Our Ref: M/73/19/HH 06-08-2019

Erection of a single storey outbuilding to be used as a washroom/garden studio
7 Sea Way Middleton-On-Sea

Garden studio & washroom

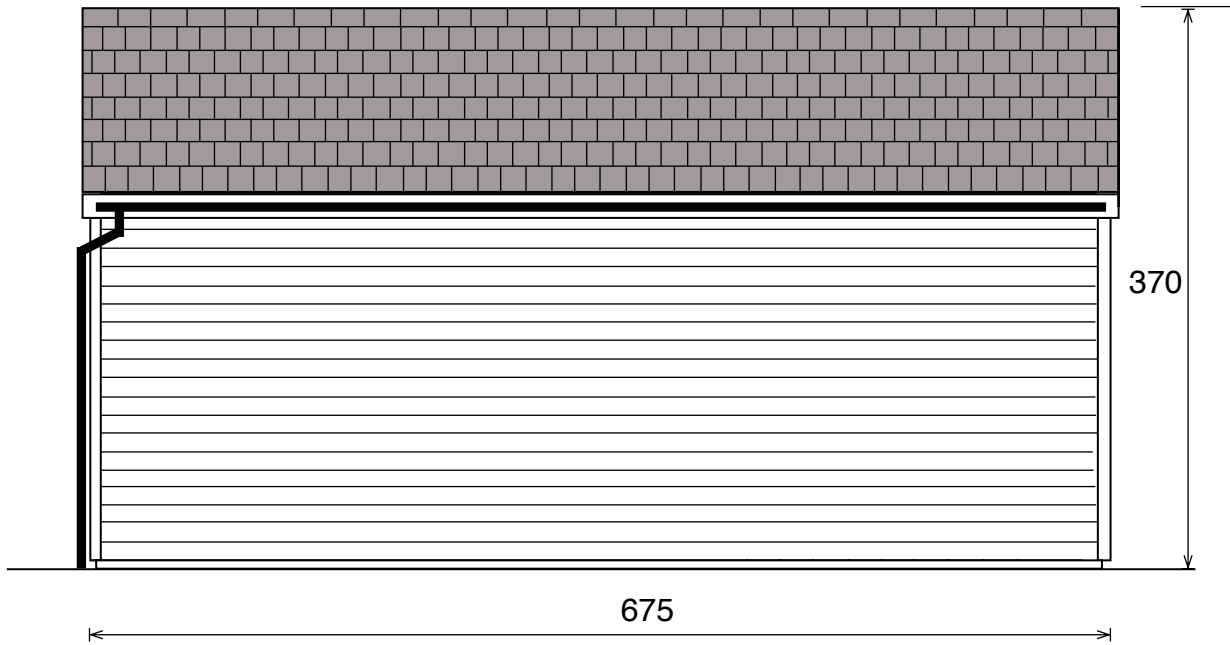
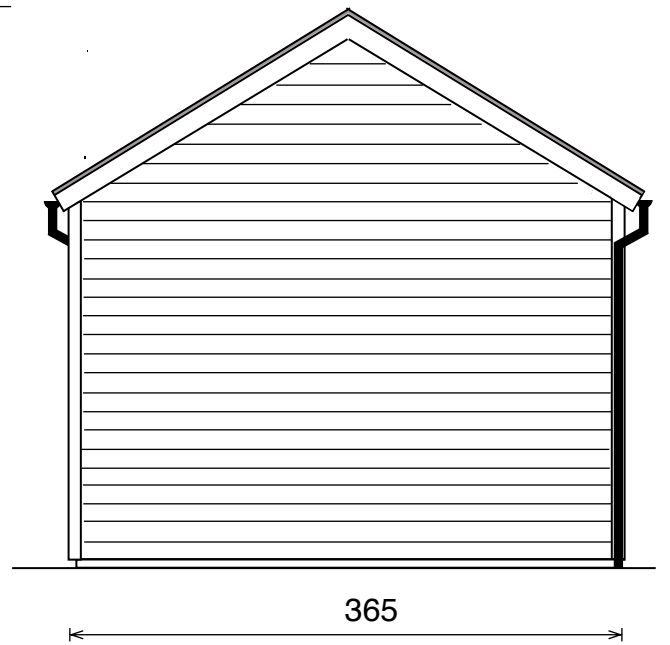
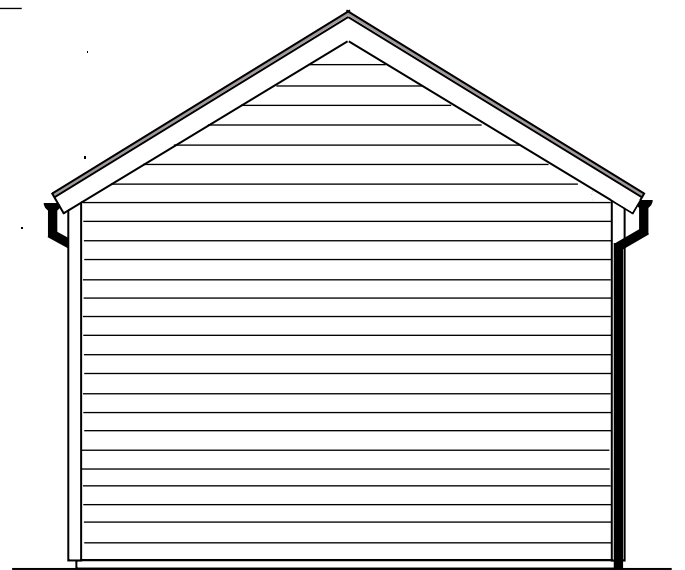
- 1. It would be built upon a relatively large proportion of the drive given that it would be 6.75 m. wide.*
- 2. The roof line would tower over the brick wall beside the grass verge outside the property, given that it will be 3.7 m. high. Nor do we want to look at a steel roof.*
- 3. It would infringe one of the guiding principles laid down by the developer of our estate which is that no building should be built less than 30 feet (10 m.) from the front boundary of a property, whereas part of the proposed building in this case will be only 0.5 m. from the wall and*
- 4. A building of this nature would adversely affect the street scene and would be contrary to the Village Design Statement.*
